RE: MOUNT PLEASANT OPERATION MODIFICATION 4 – REQUEST FOR ADDITIONAL INFORMATION

Further to your email on 21 August 2018 requesting some additional information regarding the supplementary cumulative PM₁₀ assessment prepared by Todoroski Air Sciences (2018) (the Supplementary Assessment) in relation to the Mount Pleasant Operation Rail Modification (Modification 4), please find below and attached MACH Energy Australia (MACH Energy) responses.

Mount Pleasant and Bengalla Cumulative PM₁₀ Assessment – Additional Information

Figure 3: Predicted incremental annual average PM₁₀ concentrations for Mount Pleasant in Year 2021 (µg/m³)

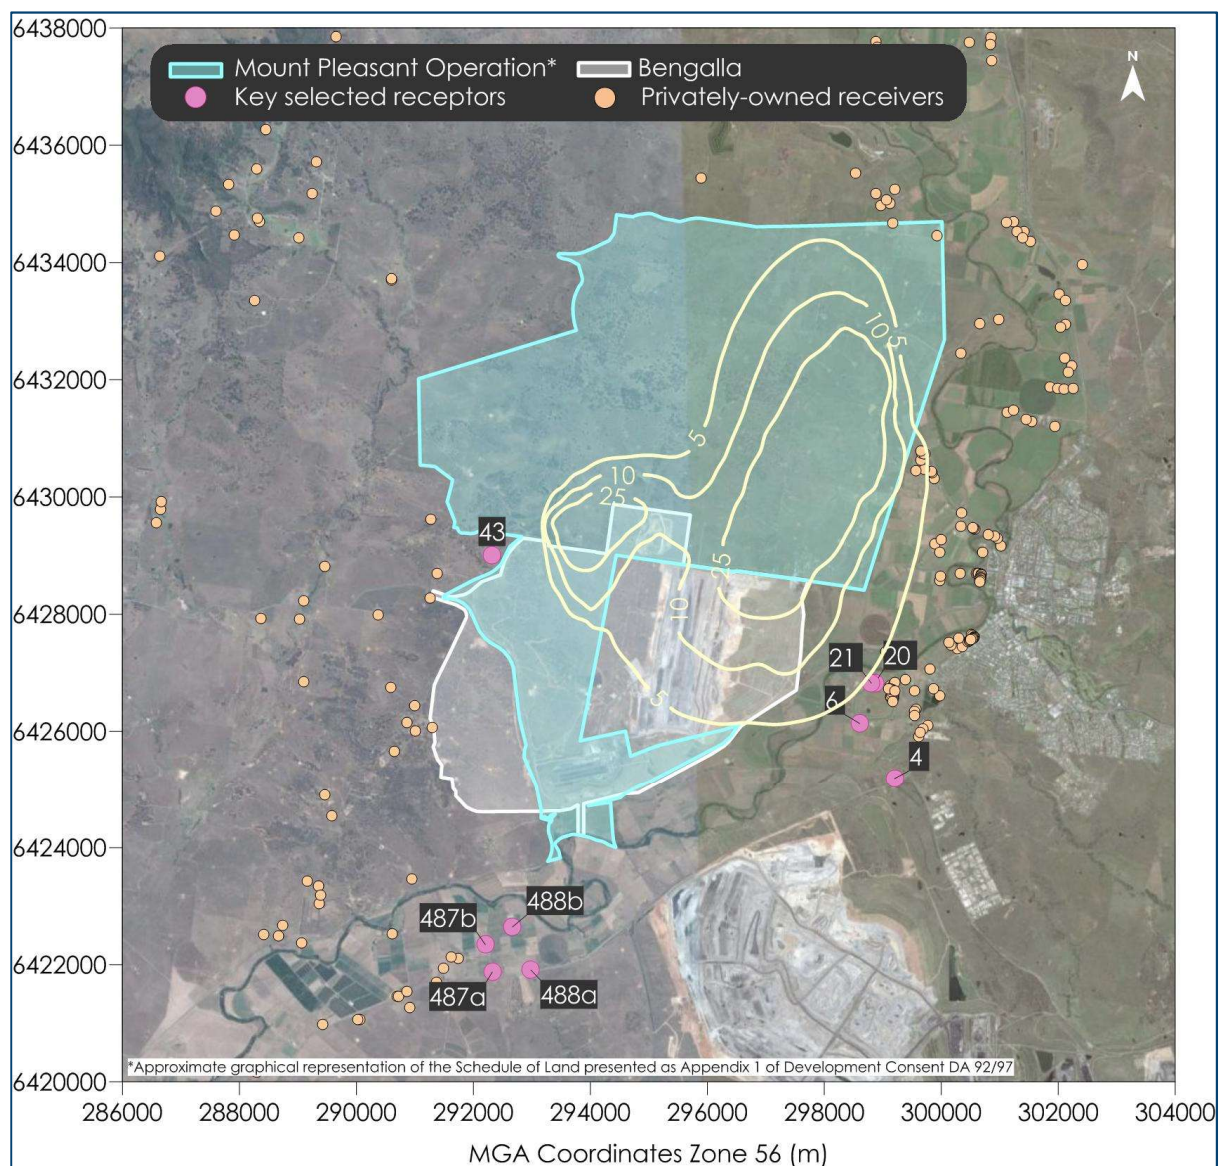
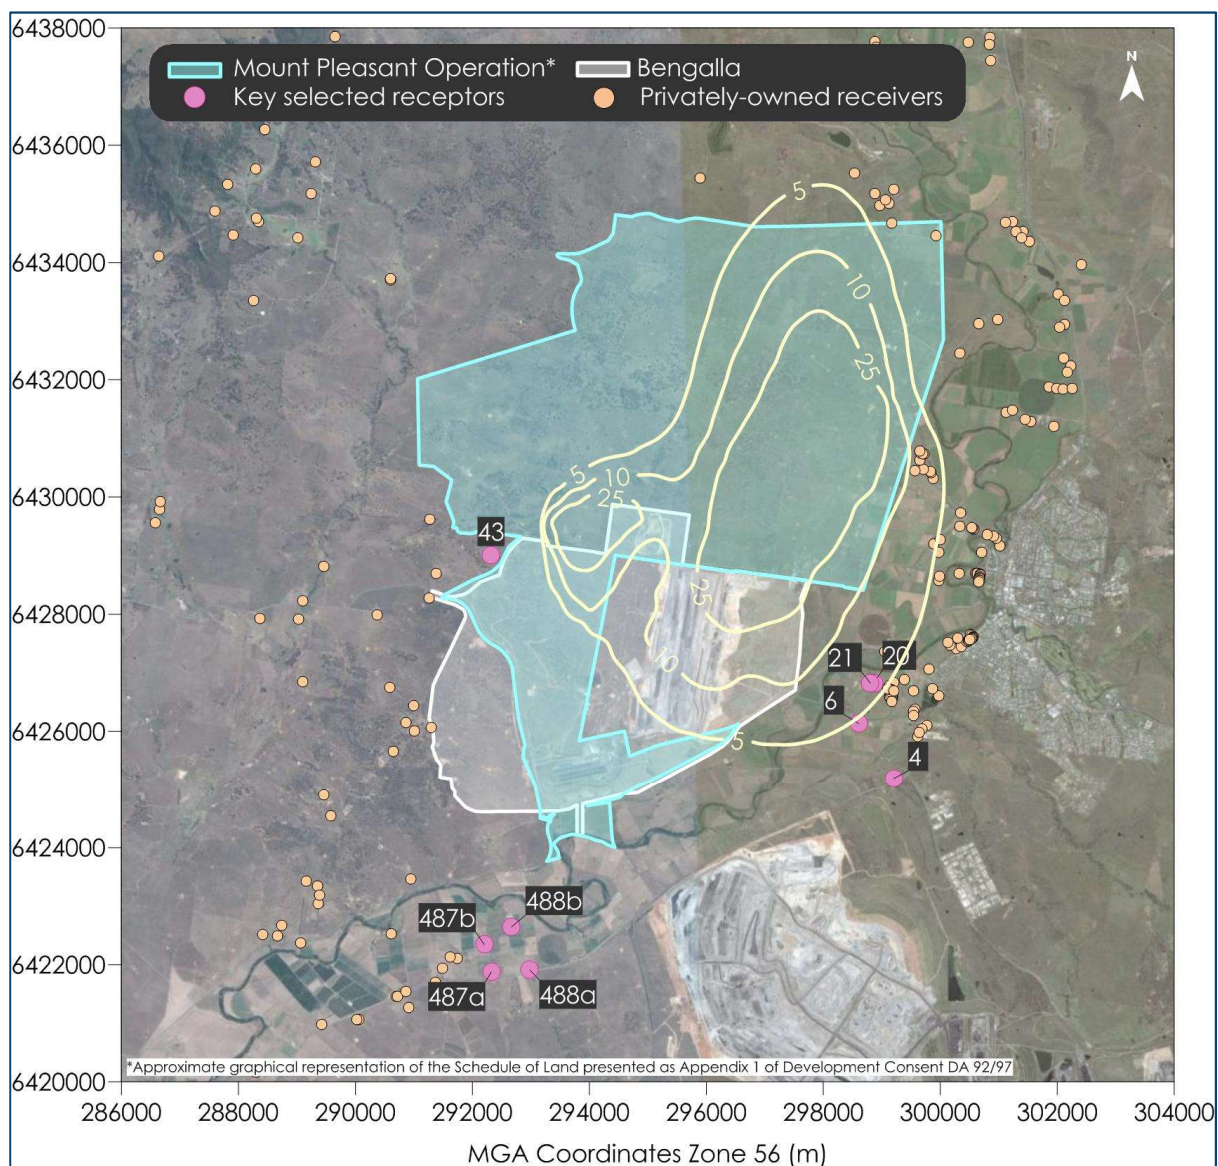
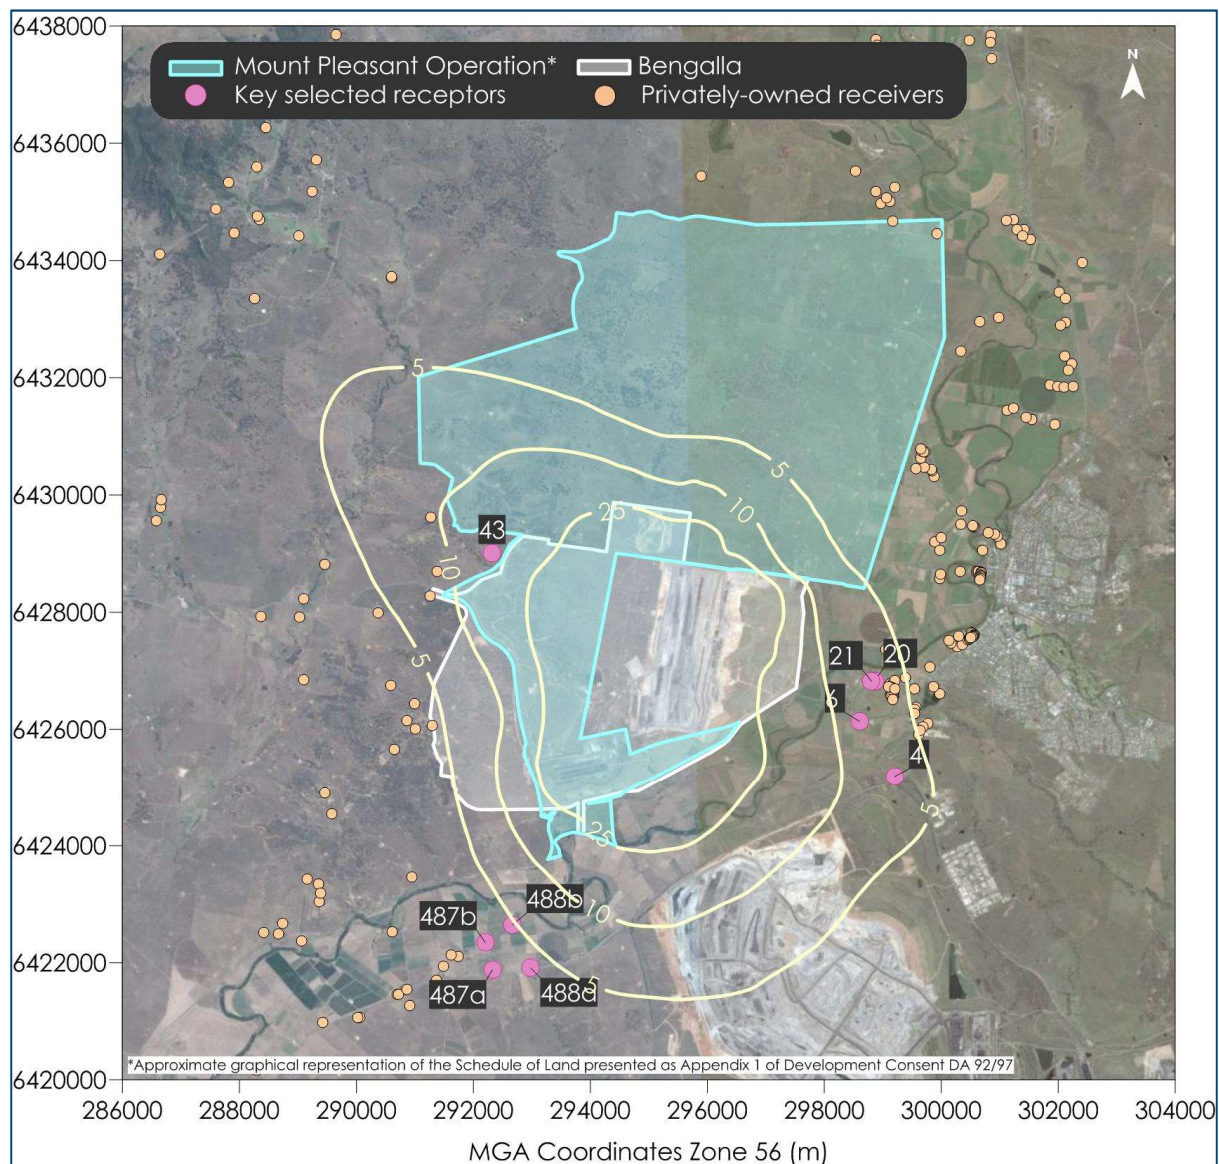
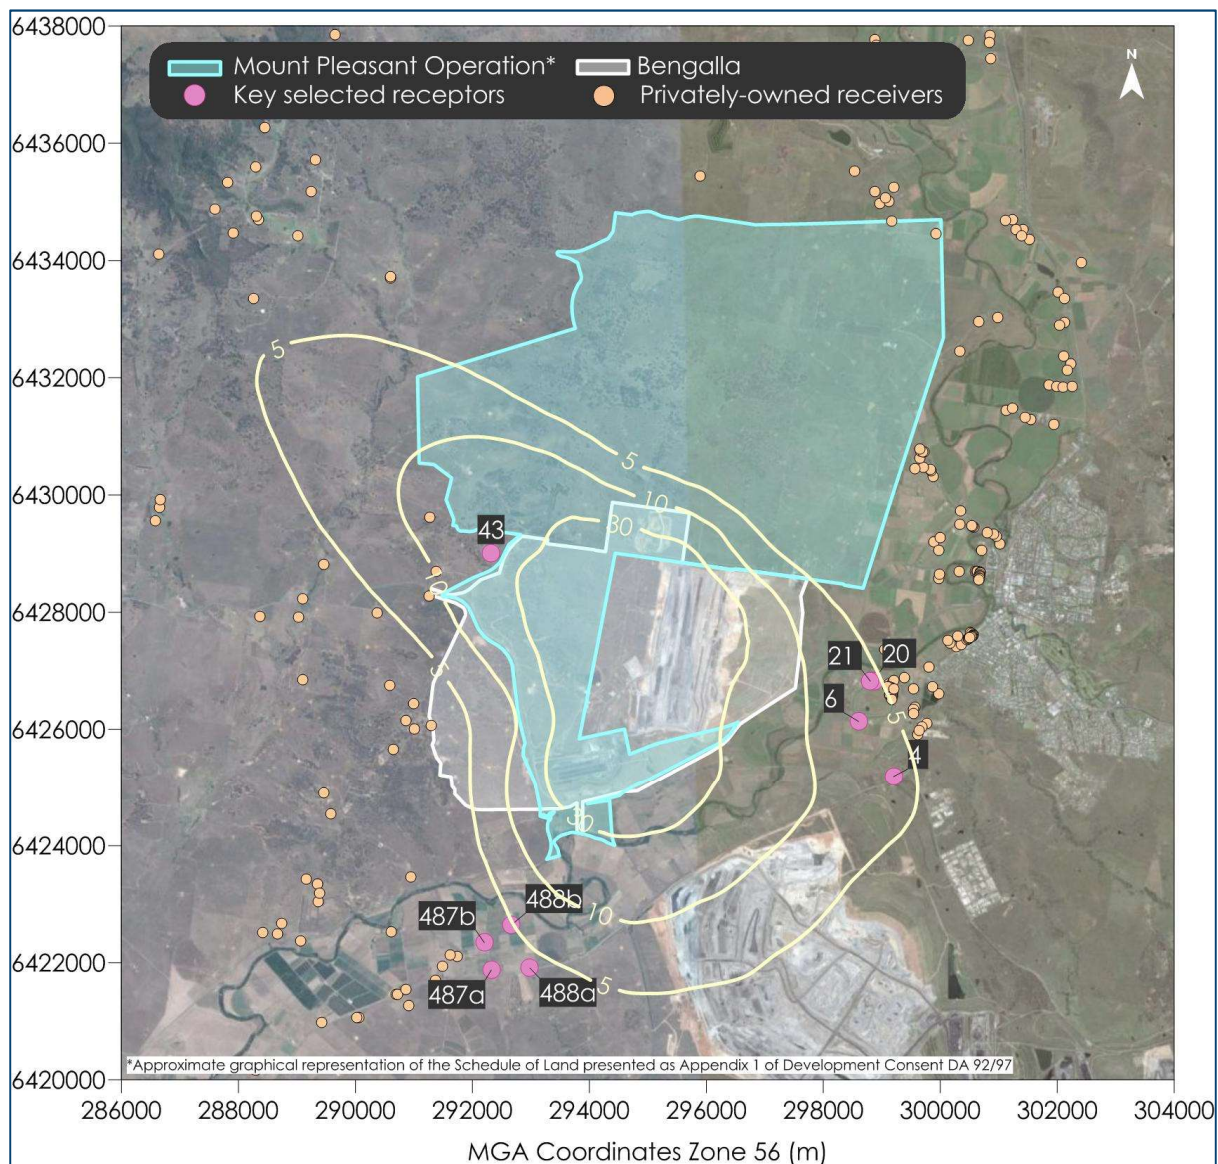
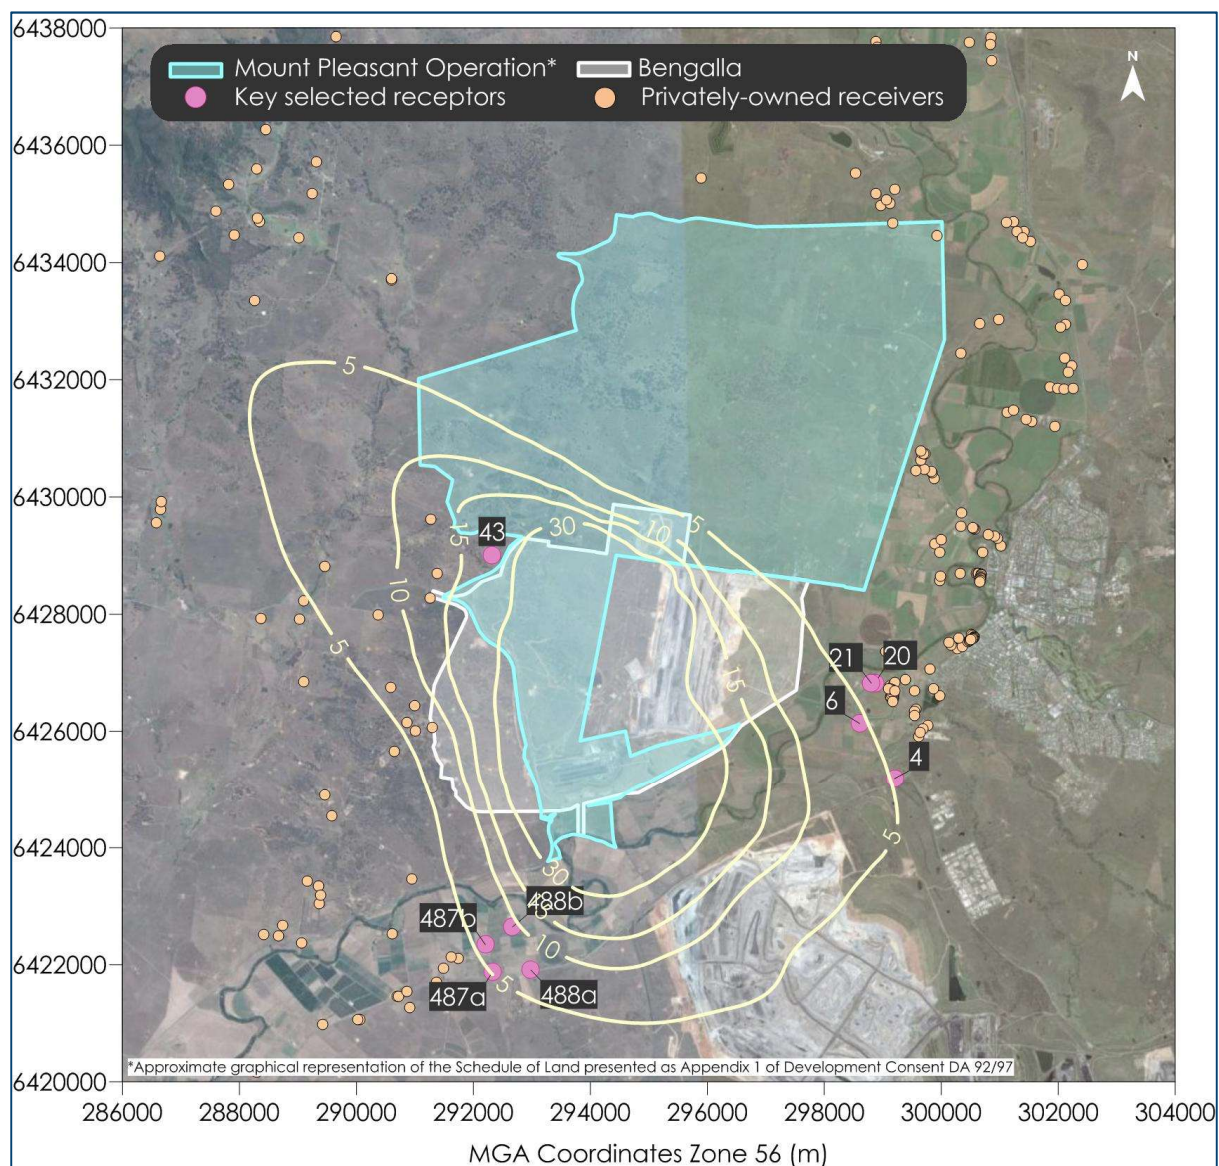
Figures 2 to 7 of the supplementary assessment provide incremental annual average PM₁₀ contours showing the respective contributions of Mount Pleasant and Bengalla operations. Please also provide cumulative annual average PM₁₀ contours, including an enlarged figure which focuses on the area surrounding Receivers 4, 6, 20 and 21.

As described in the Supplementary Assessment, a semi-quantitative assessment was completed to remove some of the conservatism inherent in the Modification 3 AQIA with regard to the modelled emissions of the Bengalla Mine at individual receivers.

Due to the differences in the modelling (e.g. modelled meteorological year), it is not readily feasible to provide suitably reliable cumulative PM₁₀ contours at this time.

Notwithstanding, it is understood BMC has commissioned Todoroski Air Sciences to undertake some further air quality assessment, including updated cumulative modelling of the Mount Pleasant Operation and the Bengalla Mine, in response to the Department of Planning and Environment letter dated 19 June 2018.

MACH Energy has provided consent for BMC to utilise meteorological and air quality monitoring data recorded at the Mount Pleasant Operation and MACH Energy modelling information for the assessment.

As the Modification 3 AQIA is the most recently approved AQIA in the area, it is expected the additional modelling would be undertaken consistent with that assessment. If this is the case, the Mount Pleasant Operation incremental emissions will be unchanged. The assessment would, however, contemporise the meteorological modelling used for the incremental modelling for the Bengalla Mine.
